DEVELOPMENT REVIEW BOARD
TRANSPORTATION DEVELOPMENT

DRB Project Number: 2019-003077
Hotel at Cutler

SUBJECT: Amendment of Approved Site Plan, Waiver to Walkway Width

ENGINEERING COMMENTS:

SITE PLAN

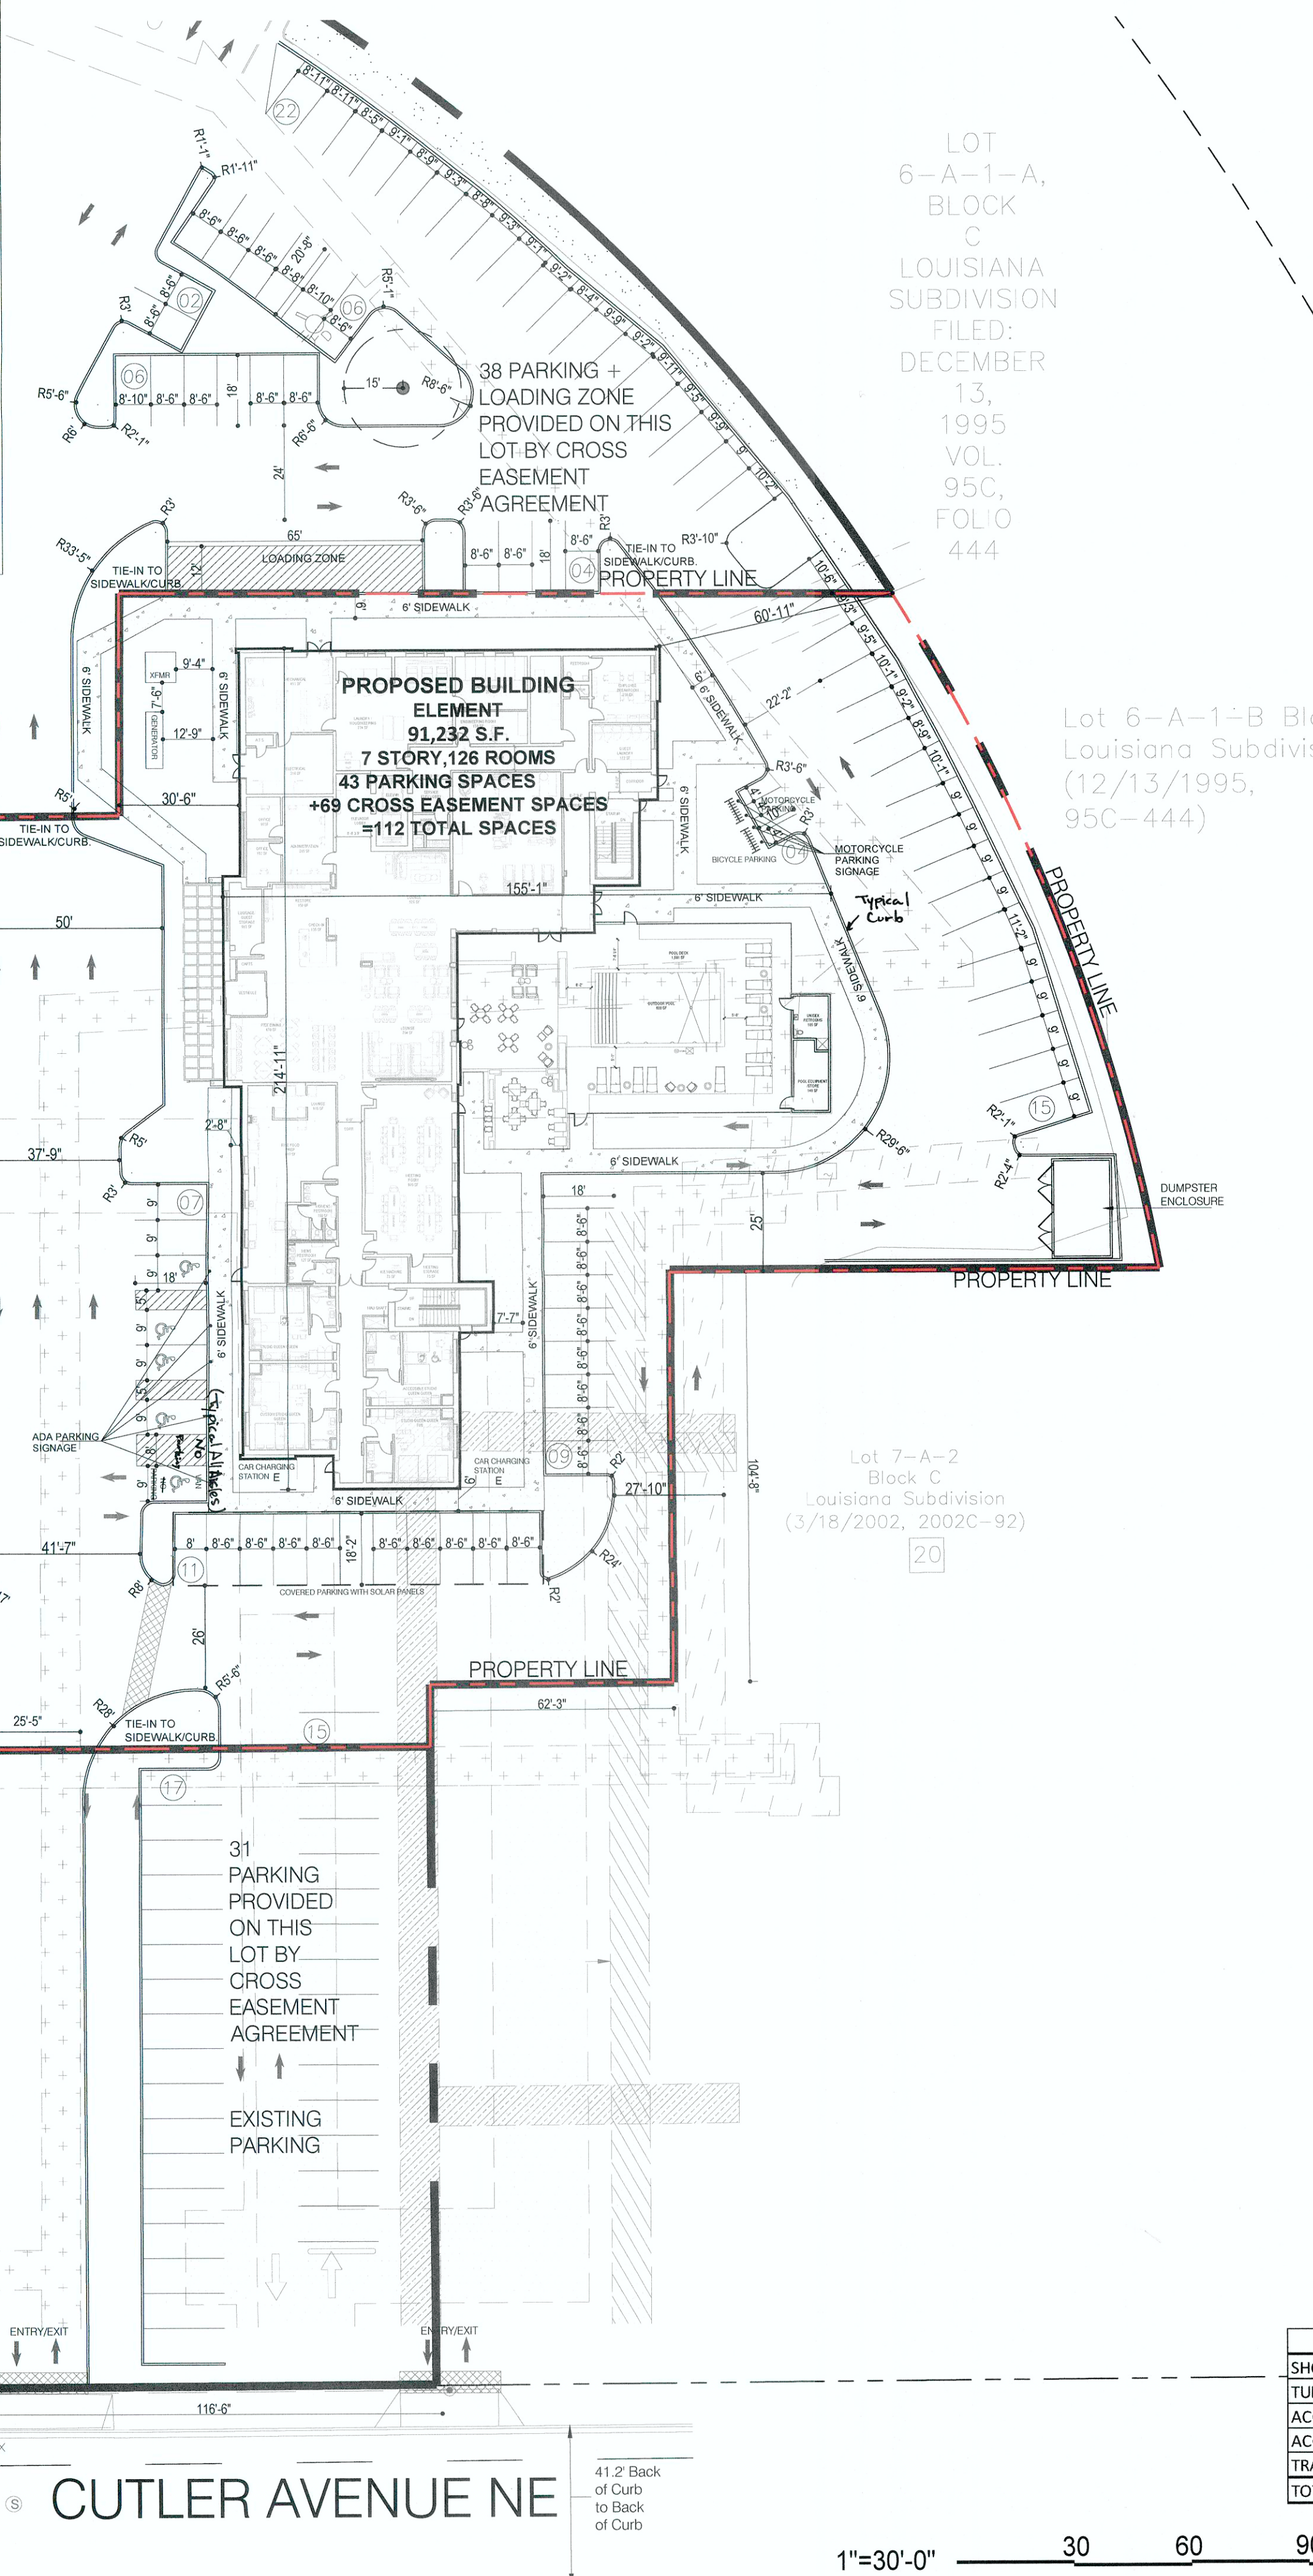
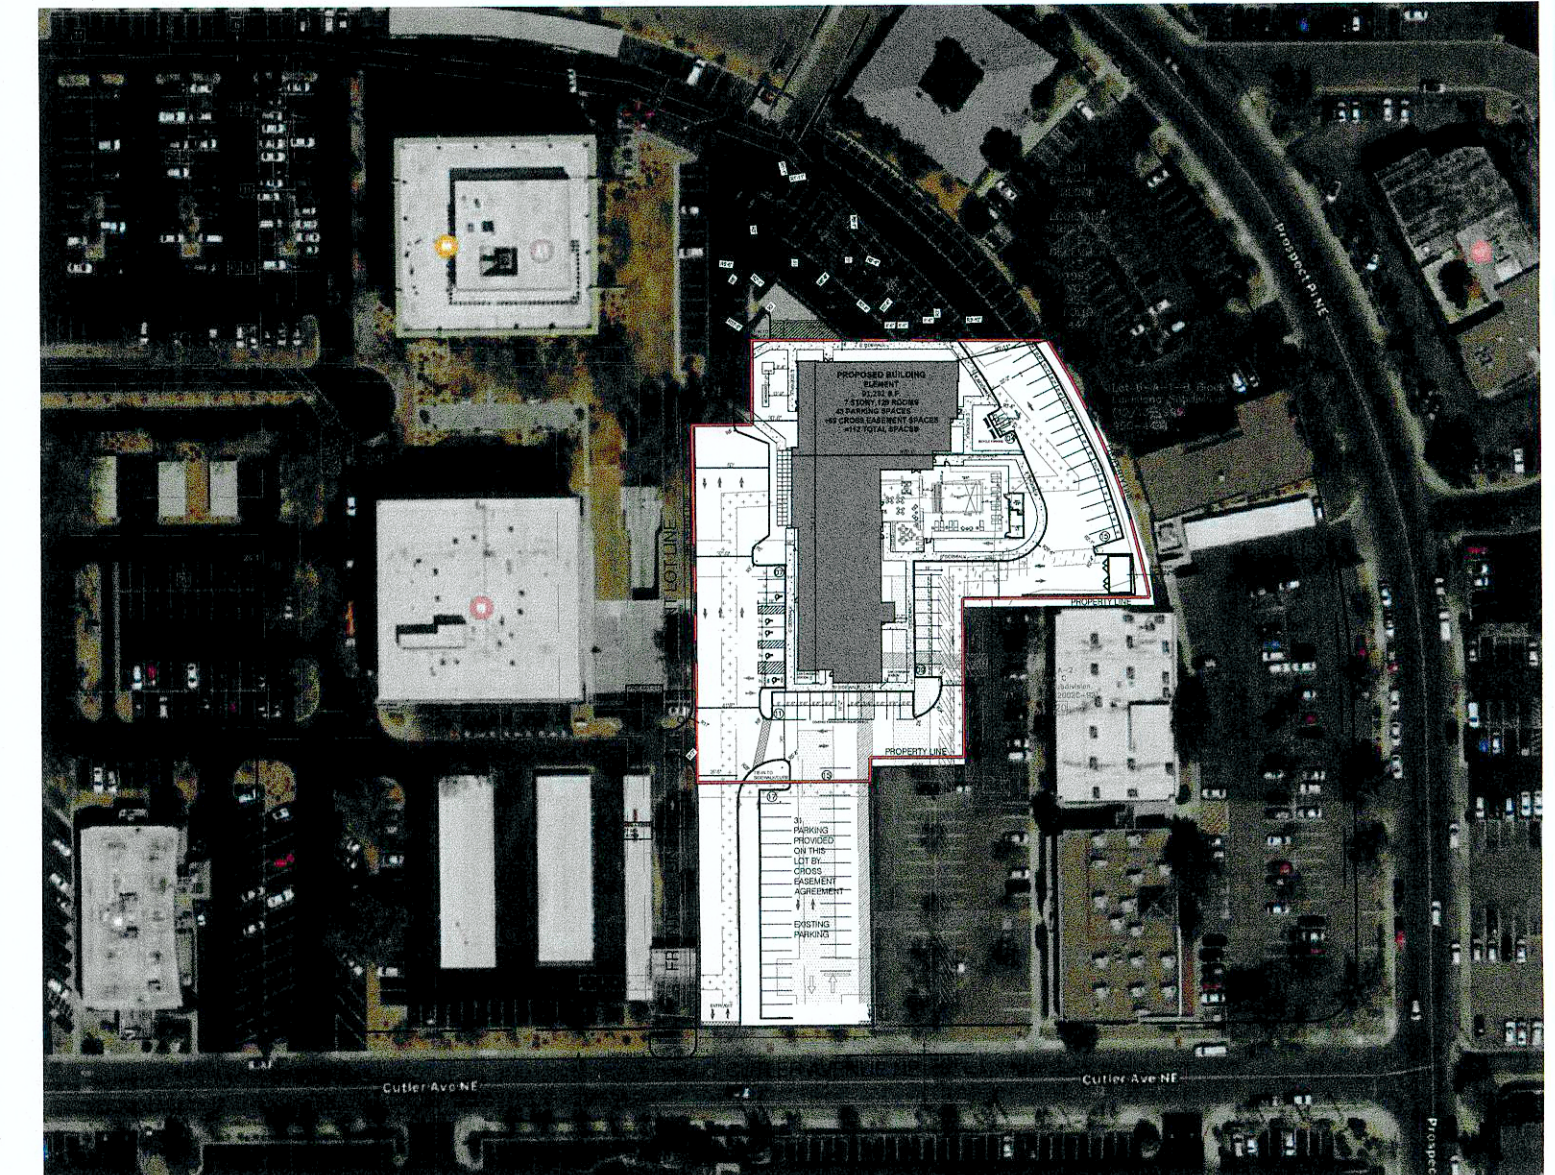
1. The Transportation Department approves the waiver to the internal walkway width based on reasons provided.
2. Clarify parking requirements. Correct parking ratio.

3. Lot lines cannot go through buildings or parking spaces.
4. Is there proposed consolidation into one lot? Otherwise, a shared access agreement will be needed with multiple lots. (A neighbor had asked about a shared access easement with the property to the east; provide any existing shared agreements.)

5. Provide existing sidewalk dimension on Cutler along with a distance from curb to property line. Right-of-way dedication may be needed.
6. Modify the driveway access off of Cutler to be ADA-compliant.

7. Label new asphalt, curb, and curb ramps and provide details. Label all curb radii. A minimum 6" or 8" curb height is required to separate parking lot from islands and walkways. Provide sidewalk detail with maximum 2% cross slope.

8. Label width of all accessways and new parking spaces.
9. Show required bicycle parking and provide bike rack location and detail per IDO requirements.

10. Label "No Parking" on pavement for the van accessible aisle.
11. Label and show motorcycle parking and handicapped signage. Provide sign details.
12. Label tie-ins to existing pavement and/or curb.

13. Show 6-foot sidewalk tie-in to existing sidewalk on Cutler Avenue.
14. Provide Fire Marshall approval for the proposed site plan.
